**Town & Country Planning Act 1990 (as amended)
Town and Country Planning (Development Management Procedure) (England) Order 2010 (as amended)
Application for Planning Permission**

Development Erection of a 3 bedroom house

Location Land adj to 6 Seafield Terrace Stocker Road Bognor Regis

FIRST FLOOR

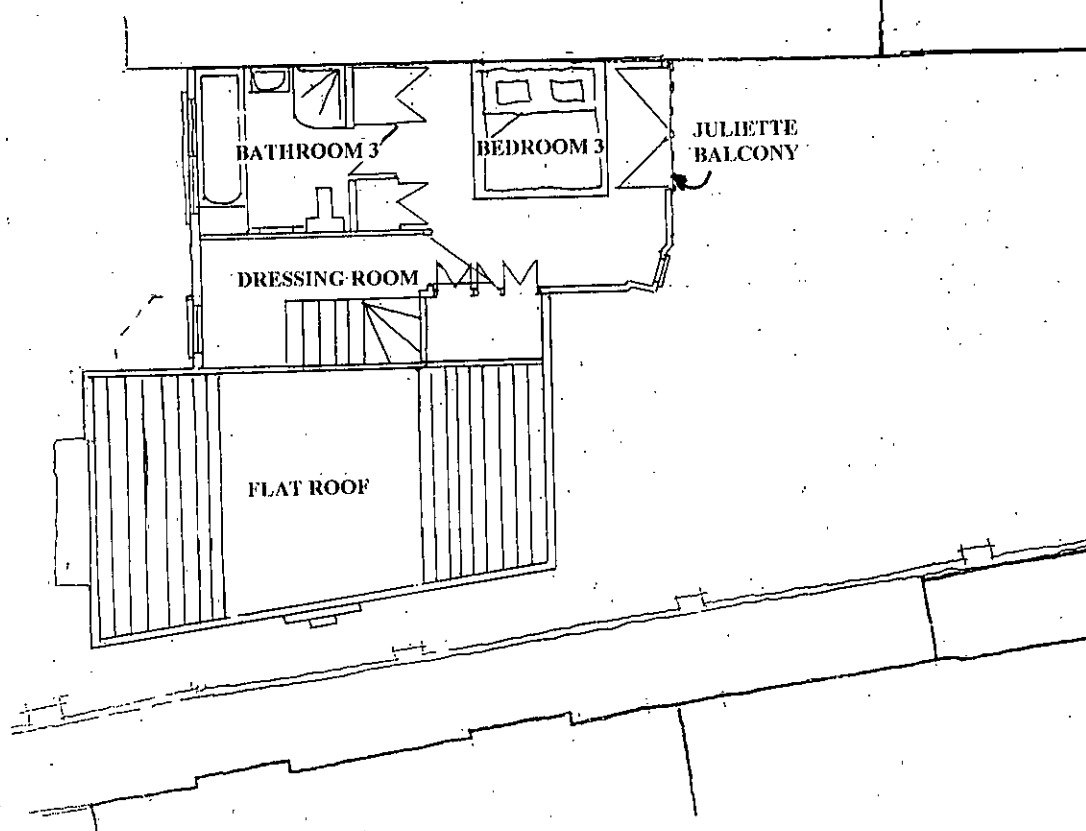
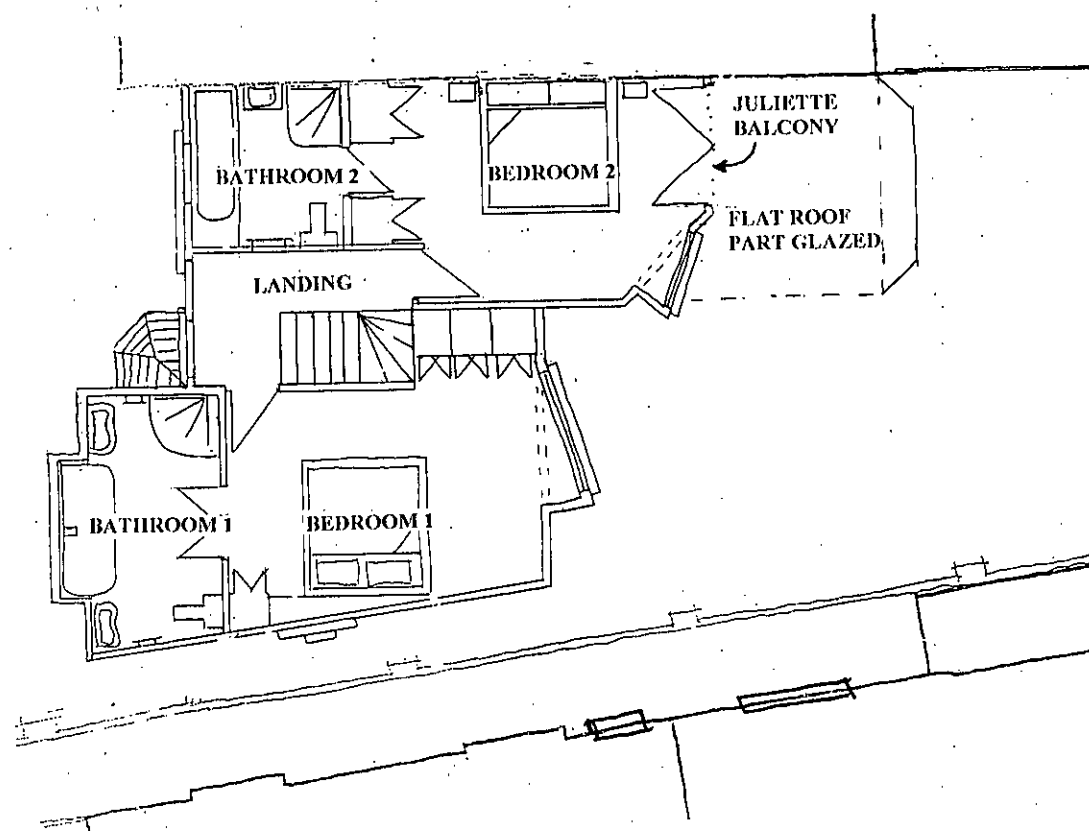
Please submit 1 electronic or 3 paper copies of revised proposed floor plans at a scale of 1:50, the submitted North first floor plans do not accord with the submitted elevations, please show all windows clearly as the ground floor have been.

Please provide revised floor plans and elevations and the plans submitted do not scale correctly.

WEST (PROPOSED)

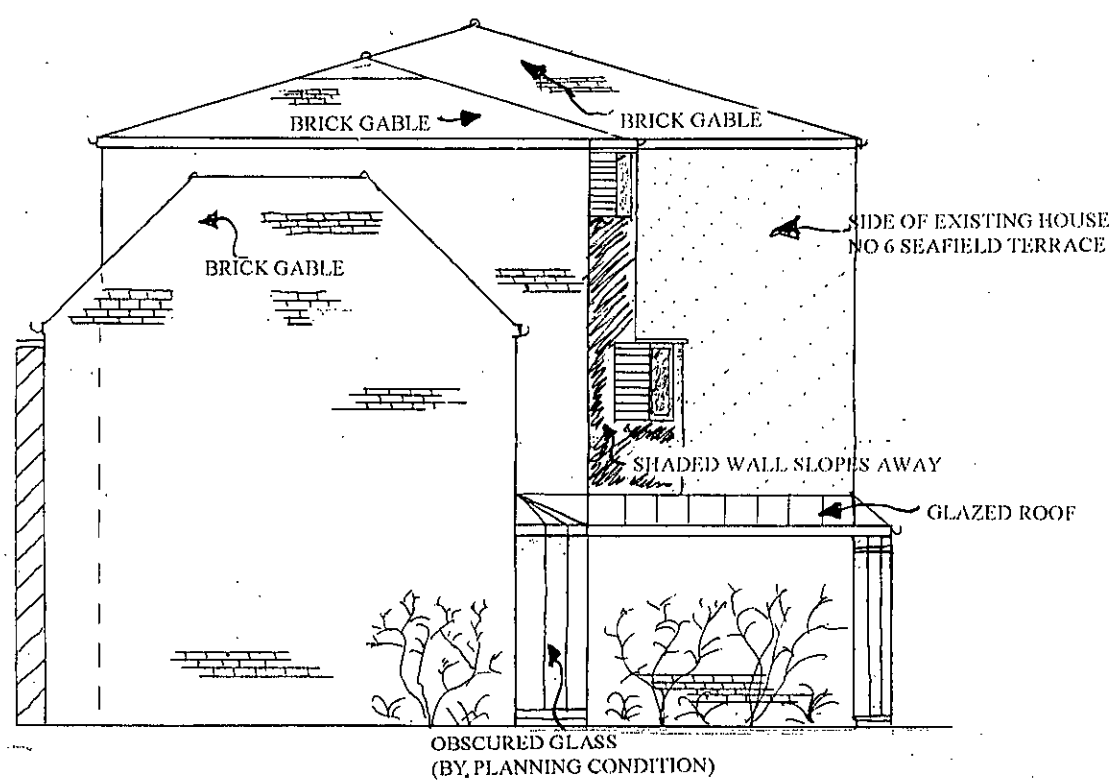
Please submit 1 electronic or 3 paper copies of proposed East and West elevations showing all windows and doors in accordance with the guidance notes available on our website detailed below (click on National List).

Roof Plan

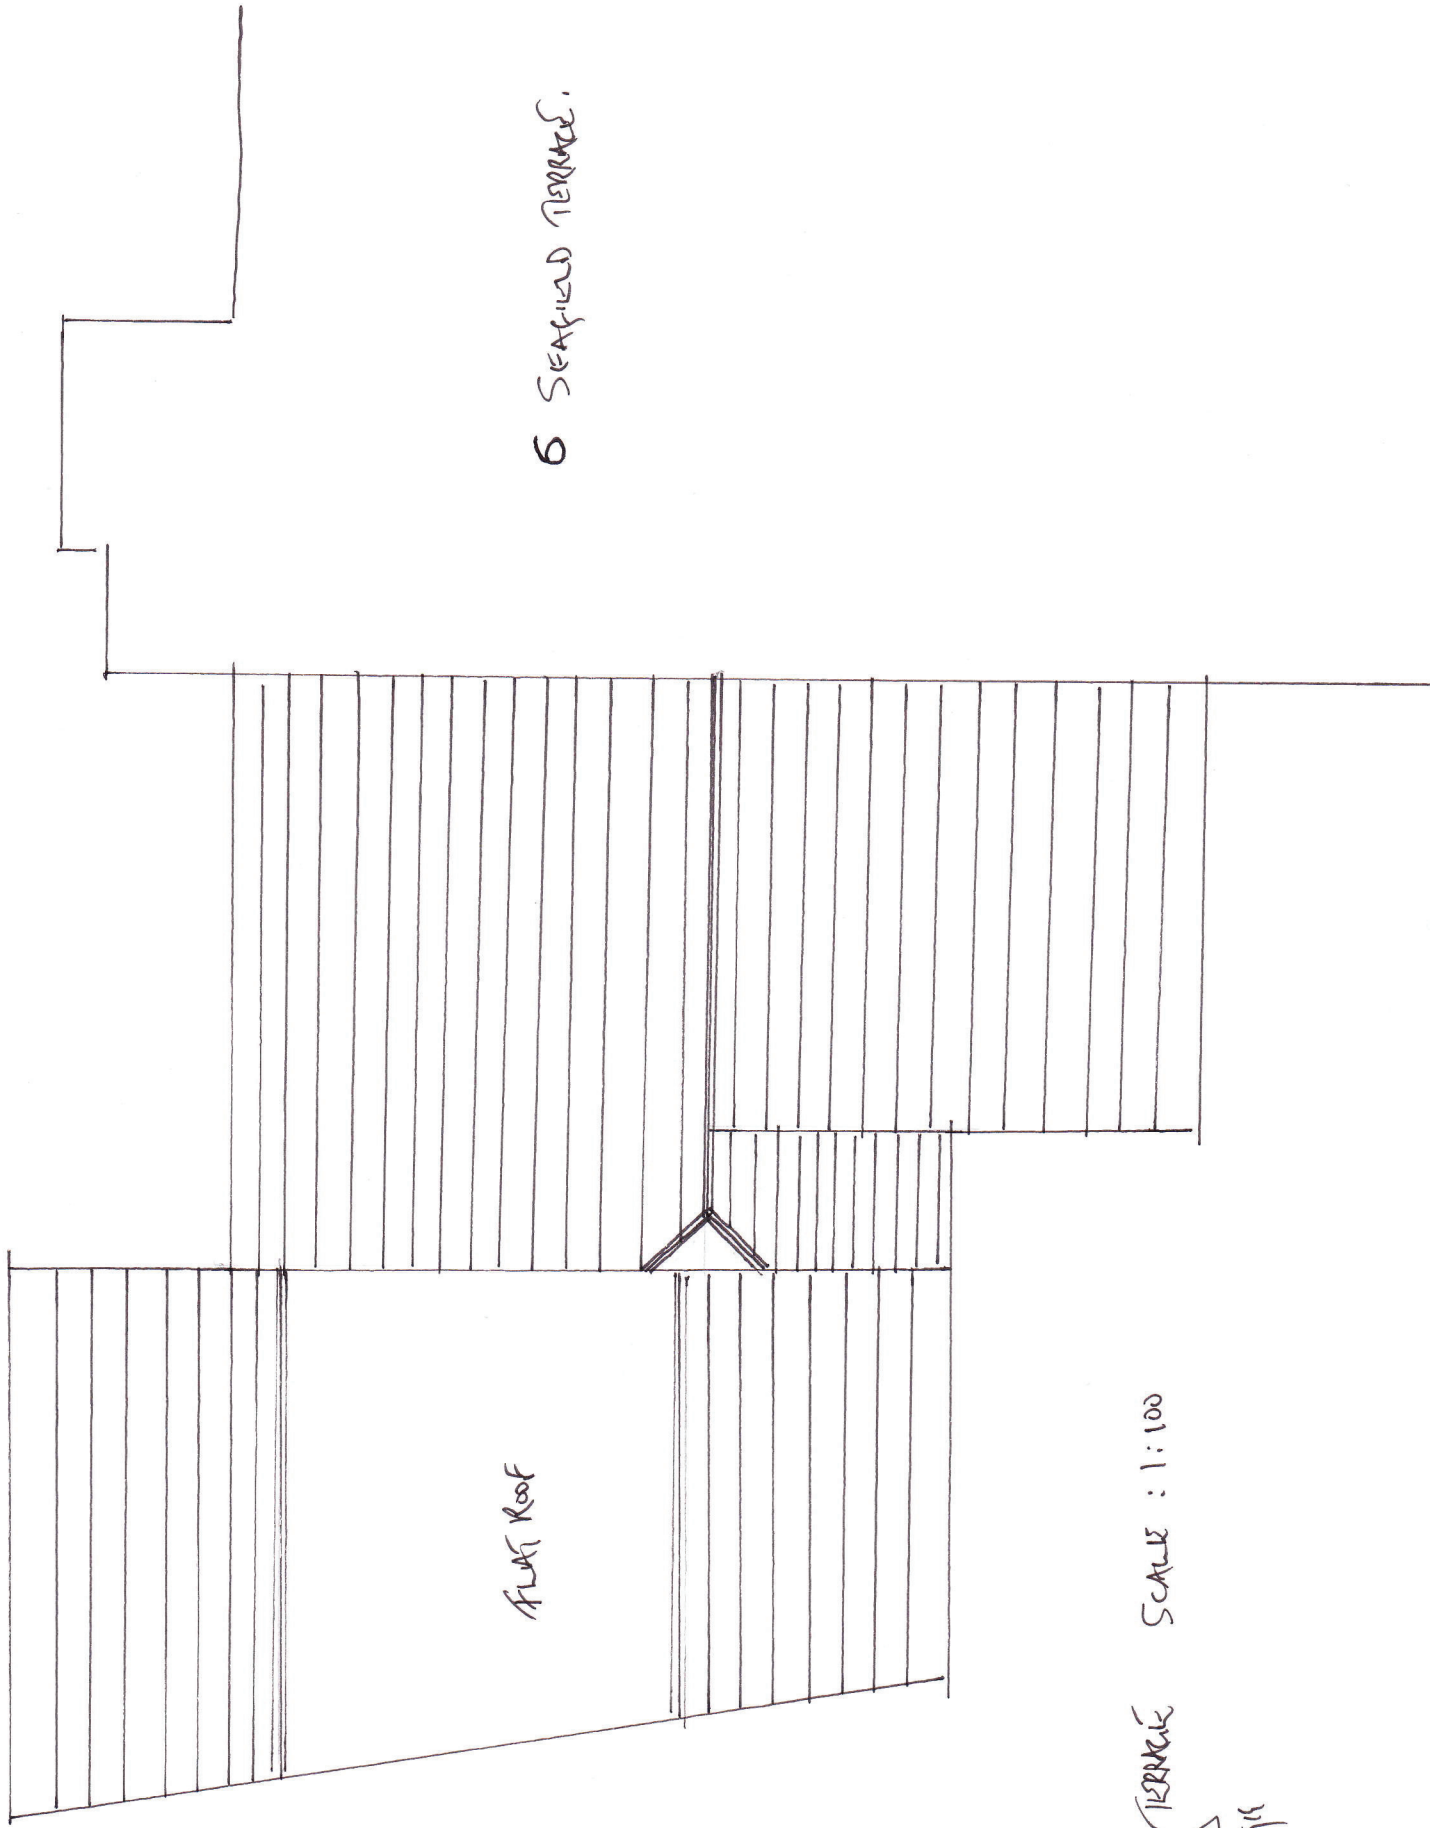
Please submit 1 electronic or 3 paper copies of proposed roof plan in accordance with guidance notes available on our website detailed below (click on National List).
